WEST SUSSEX COUNTY COUNCIL CONSULTATION

TO:	Arun District Council FAO: Zac Denton
FROM:	WSCC - Highways Authority
DATE:	9 December 2020
LOCATION:	Land East Of Kingston House, Kingston Lane, Kingston, BN16 1RP
SUBJECT:	K/54/20/PL Single storey 4 bed dwelling & stable block (resubmission following K/16/19/PL. This application is a Departure from the Development Plan & is in CIL Zone 3 & is CIL Liable.
DATE OF SITE VISIT:	N/A
RECOMMENDATION:	Advice
S106 CONTRIBUTION TOTAL:	N/A

Client		Description	
		SITE PLAN & EXISTING TOPOGRAPHICAL

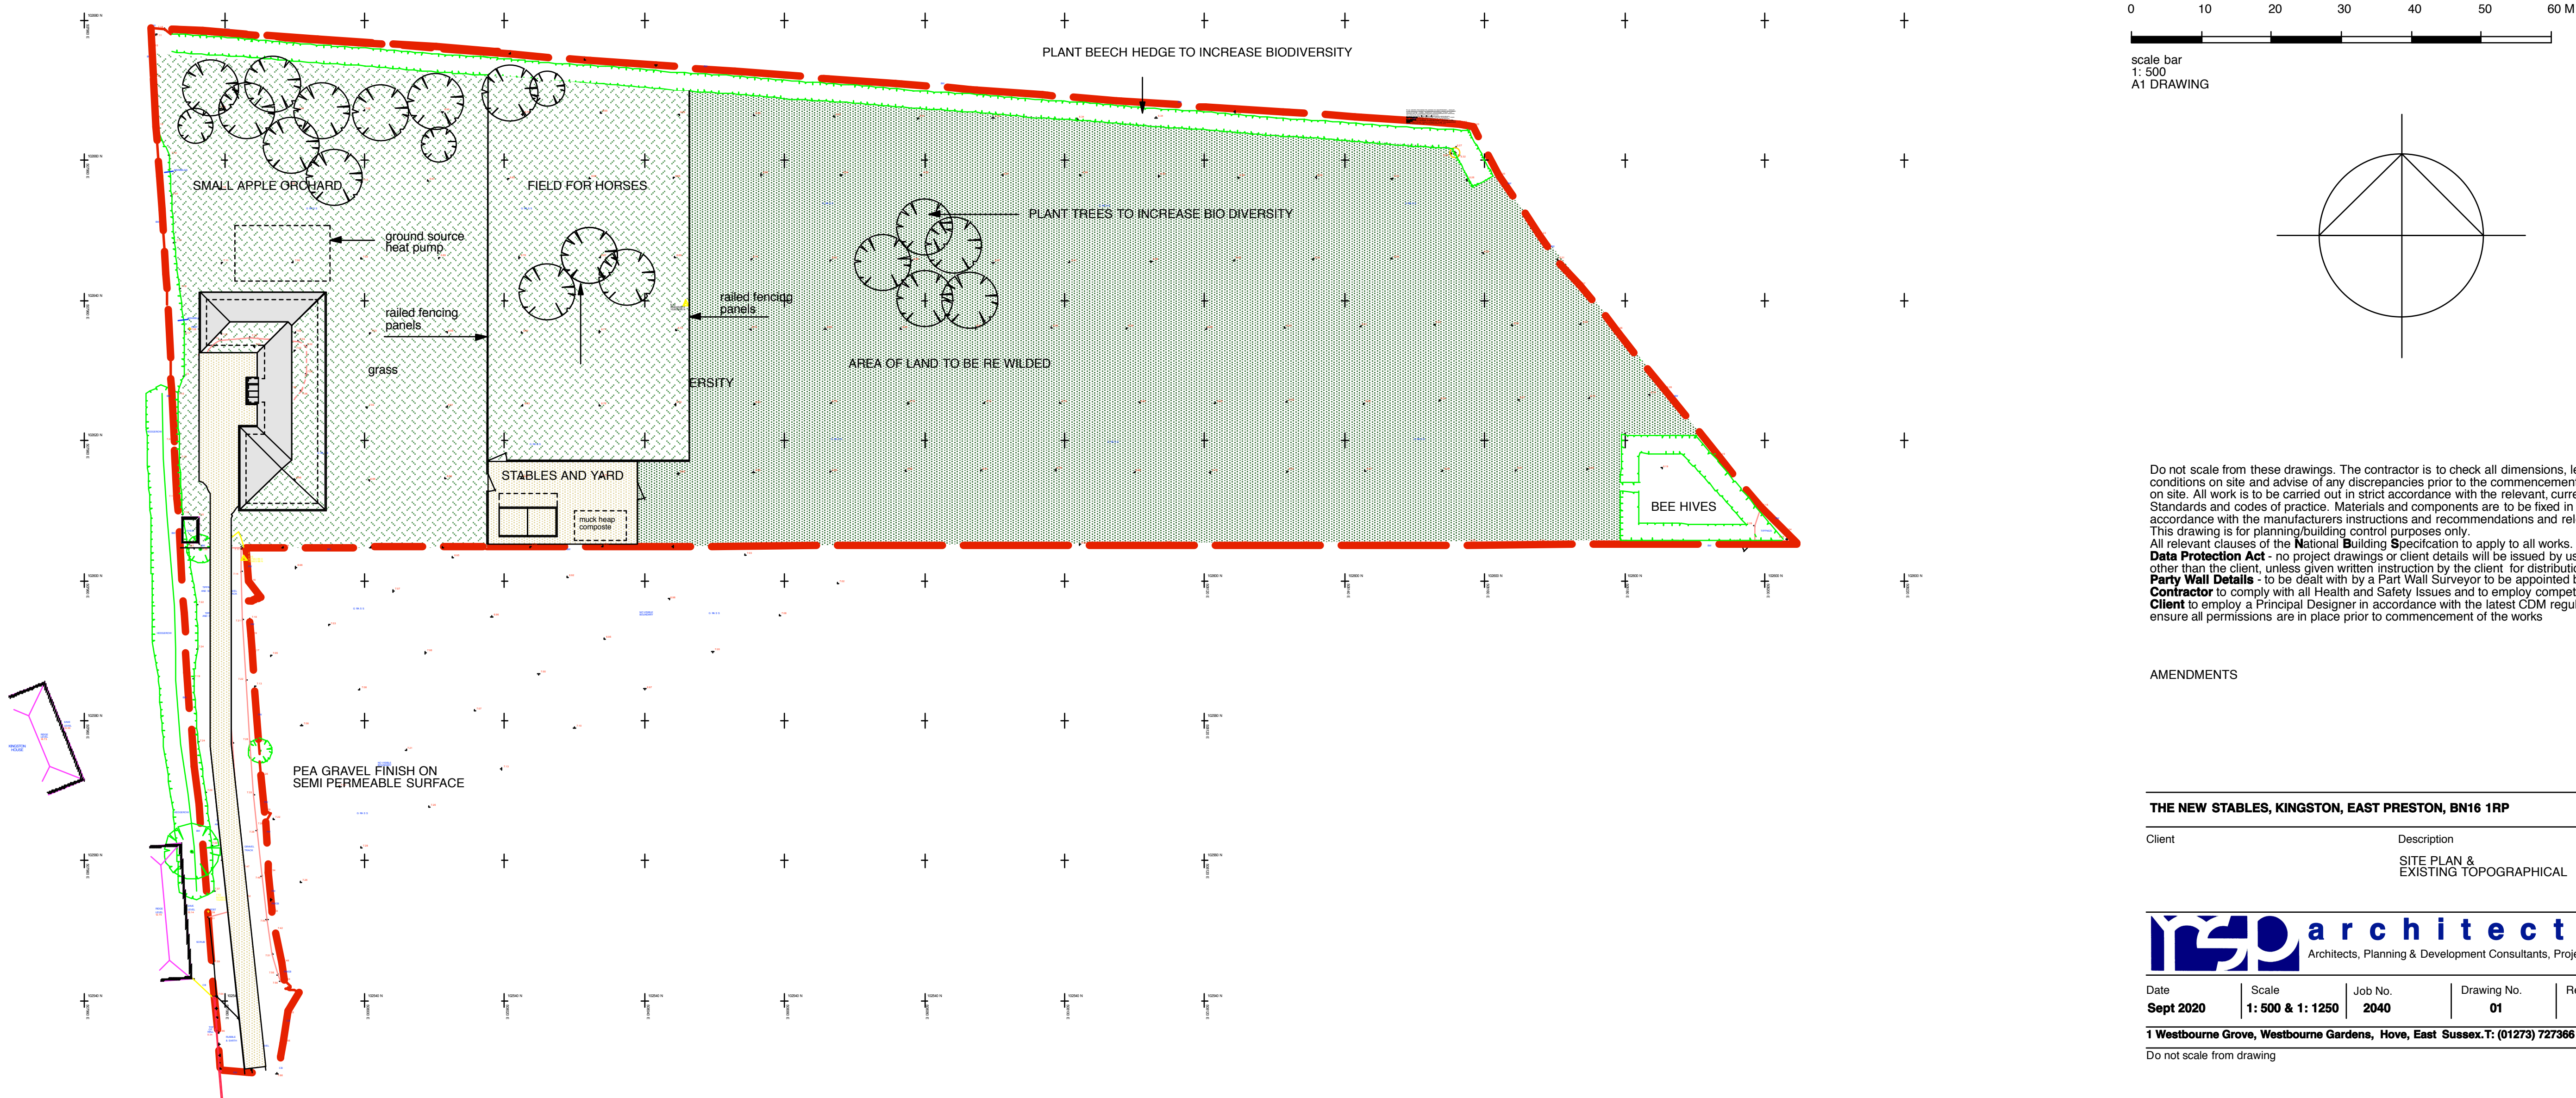
The applicant proposes to utilise the existing access on Kingston Lane. A private access track, which is partly maintained as Public Footpath no. 2114_1, shall connect the proposed dwelling to the maintained highway. There are no apparent visibility issues with the existing point of access onto Kingston Lane. The LHA does not anticipate that this proposal would give rise to a significant material intensification of movements to or from the site.

For vehicular parking provision, the applicant proposes a double-car garage and driveway for this development. The garage is of suitable size to allow for two car parking spaces, in accordance with the minimum specifications for garages set out in Manual for Streets (MfS). There is also additional space for at least two car parking spaces within the driveway, and space for on-site turning. Under Arun Parking Standards, at least three car parking spaces would be required for a dwelling of this size in this location. Therefore, the LHA considers the proposed parking provision to be sufficient.

Regarding cycle parking, this could be accommodated either within the double-car garage or the shed. The inclusion of secure and covered cycle parking helps promote the use of sustainable alternative modes of transport to the private car.

No part of the development shall be first occupied until the car parking has been constructed in accordance with the approved site plan. These spaces shall thereafter be retained at all times for their designated purpose.

No part of the development shall be first occupied until covered and secure cycle parking spaces have been provided in accordance with plans and details to be submitted to and approved by the Local Planning Authority.
